RE: Stone Short Plat (SP-08-00043)

The Kittitas County Community Development Services Department has determined that the Stone Short Plat (SP-08-00043) is a complete application and hereby grants *conditional preliminary approval* subject to the following conditions:

**STONE SHORT PLAT**

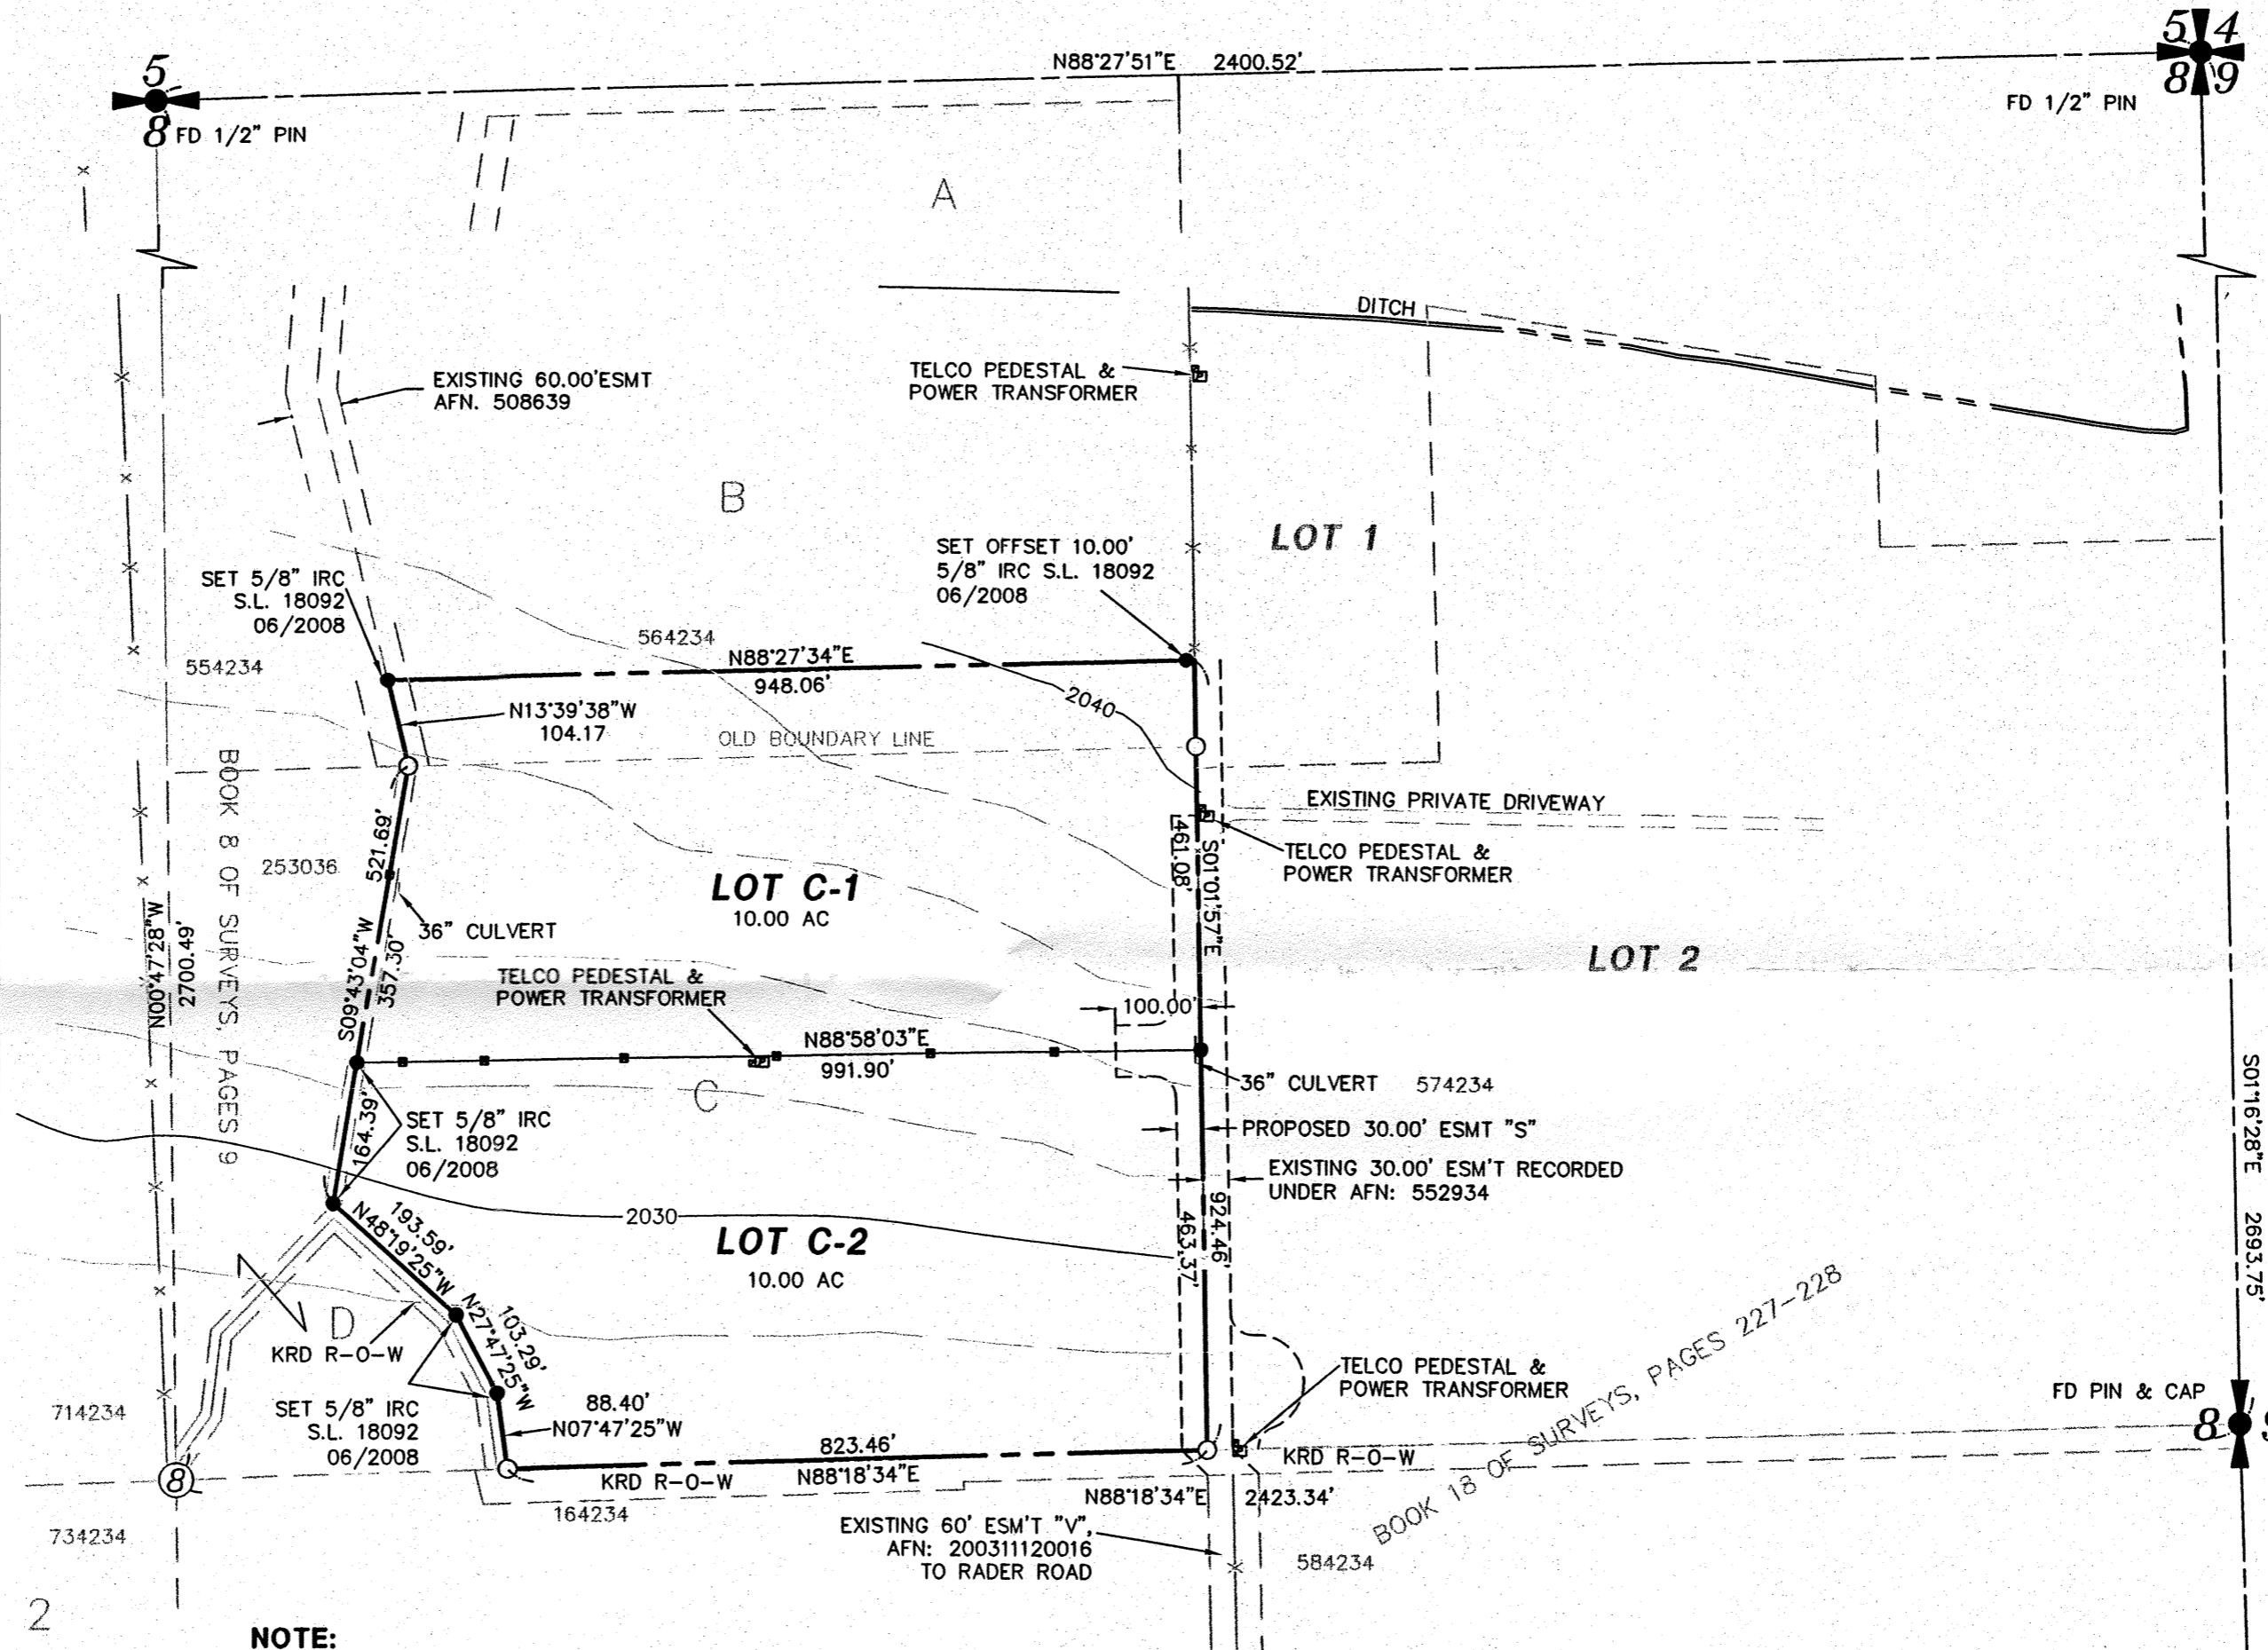
1. Both sheets of the final mylars shall reflect short plat number SP-08-00043 and an accurate legal description shall be shown on the face of the final plat.

4. The applicant will need to resubmit the plat drawing to reflect the location of the existing well.
5. Property owners shall be required to demonstrate by metering or other means compliance with the single project withdrawal limitation of 5,000 gallons.
